Transport

EXHIBITION OF ENVIRONMENTAL ASSESSMENT FOR 132-138 KILLEATON STREET, ST IVES (MP10_0057)

I refer to your letter dated 24 August 2010 seeking advice on the Environmental Assessment for the above mentioned project. Transport NSW (TNSW) appreciates the opportunity to provide input to this application.

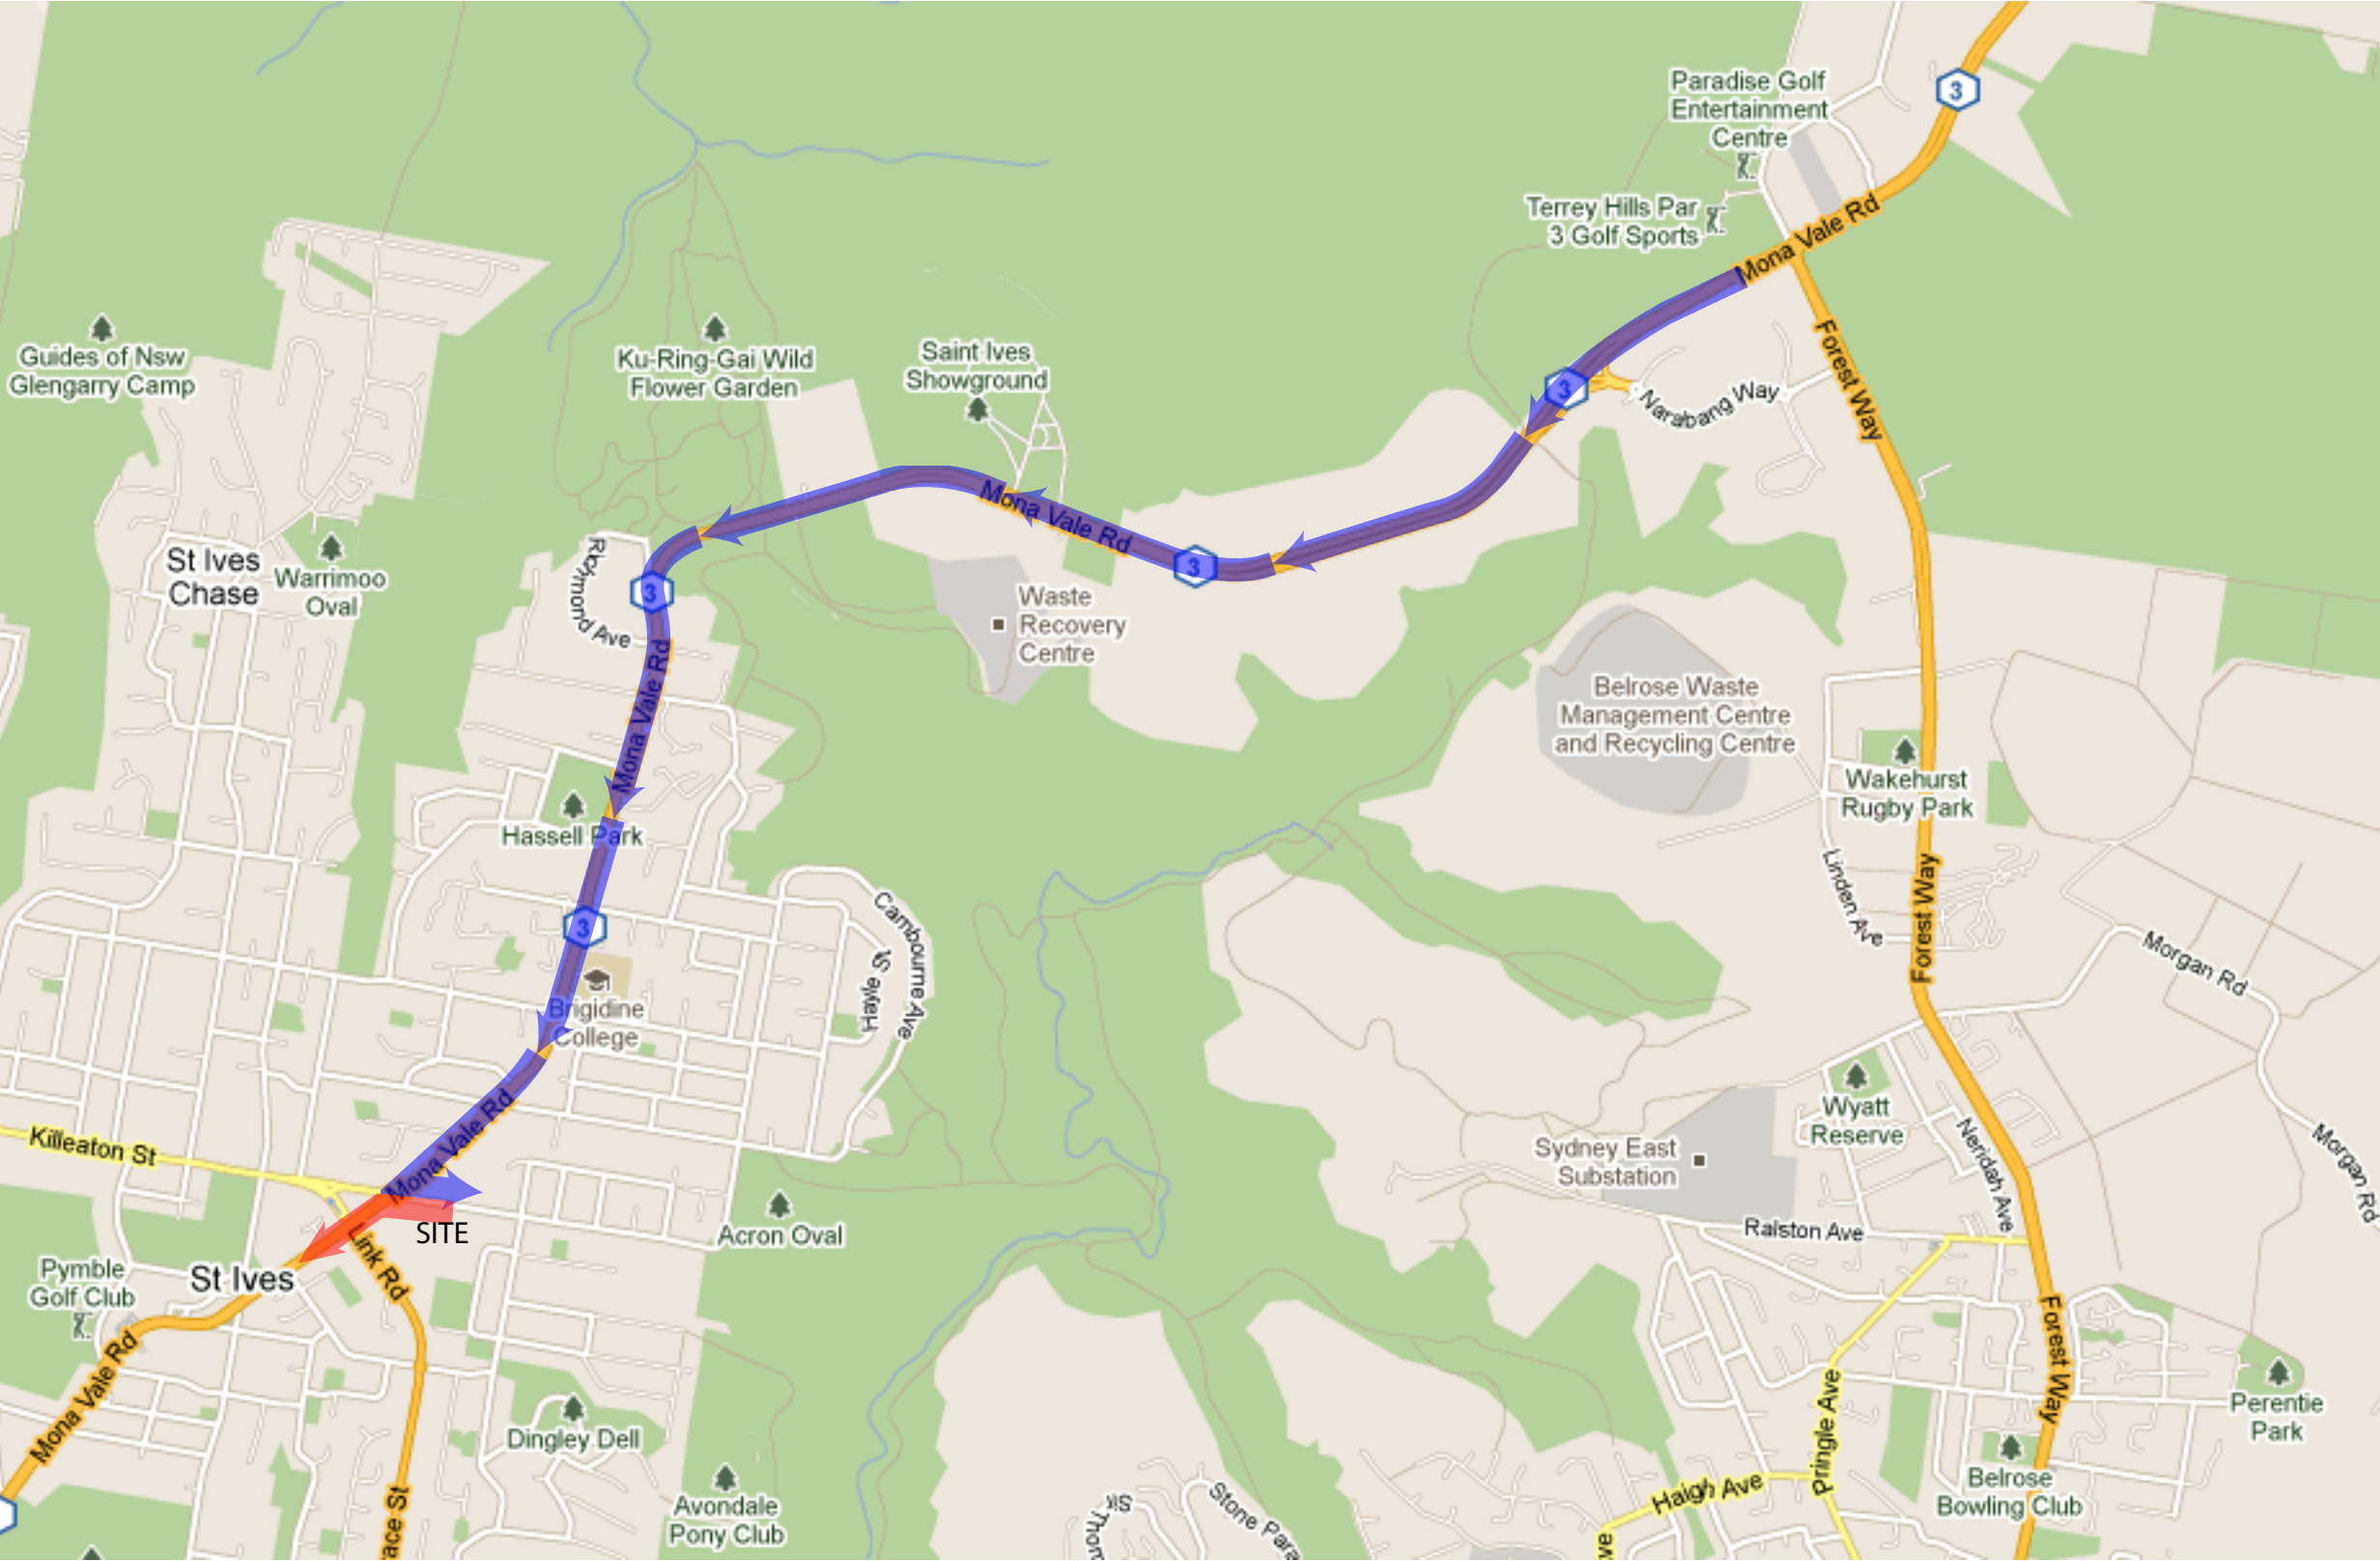
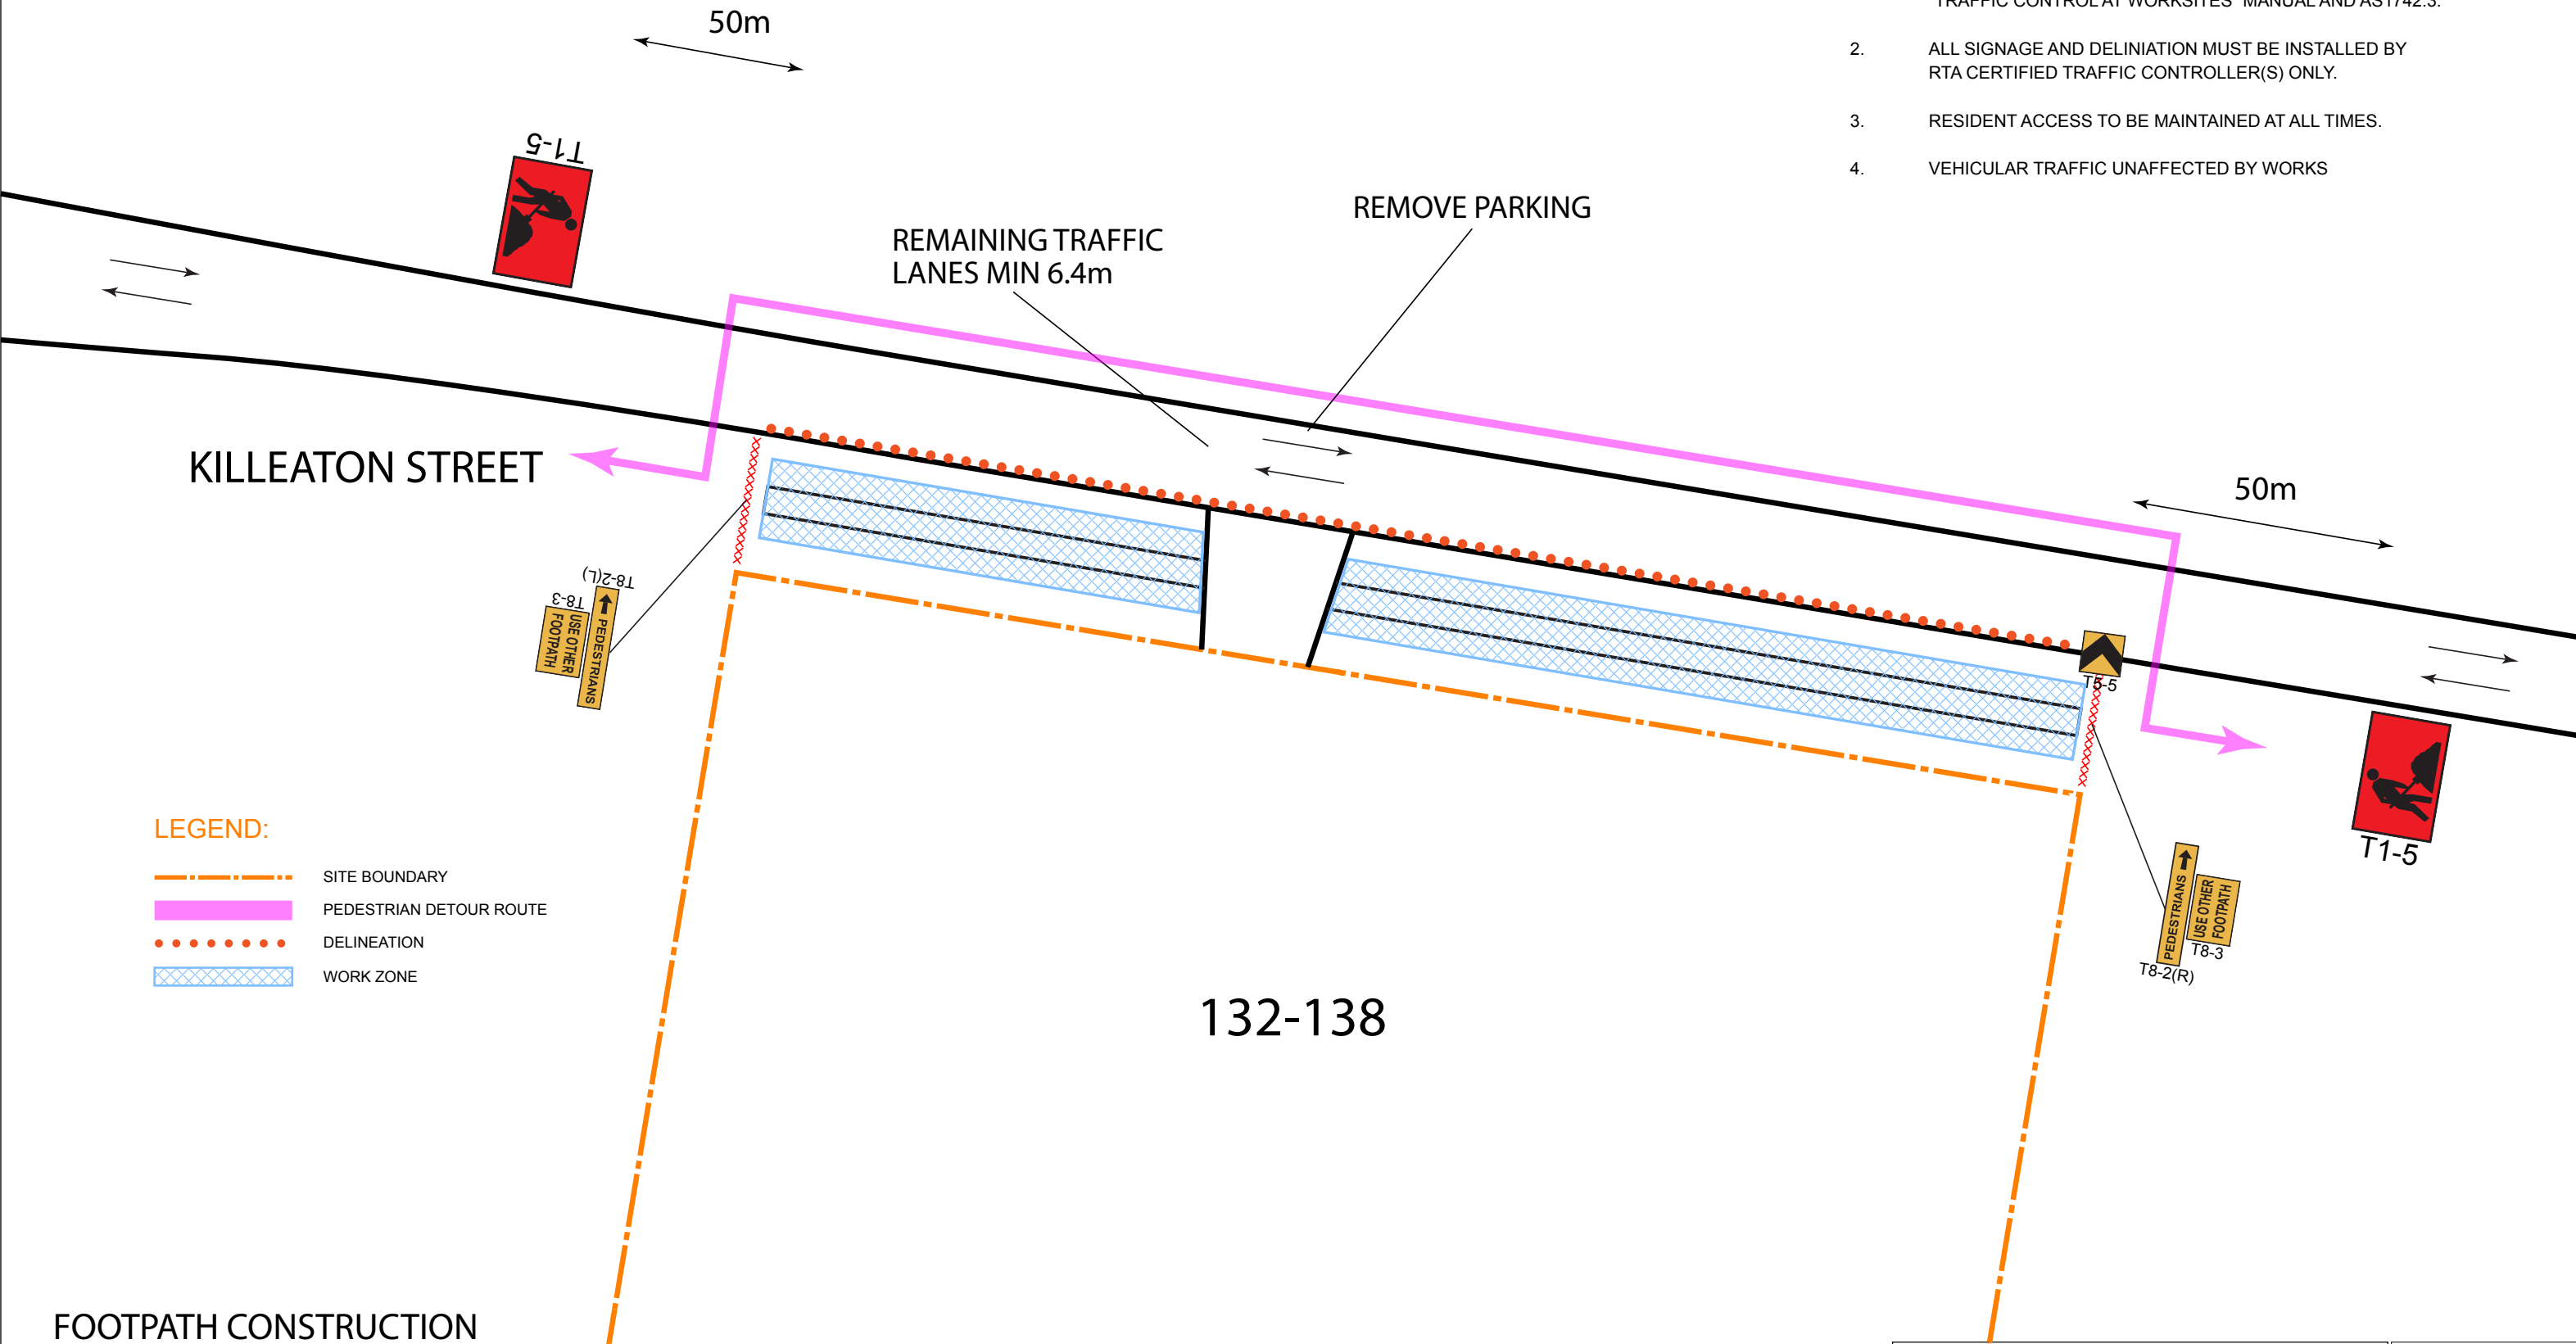
3. Preparation of a Construction Traffic Management Plan (CTMP) to mitigate any potential impacts to accessibility, amenity and safety of public transport users and people traveling on foot or bicycle during construction.
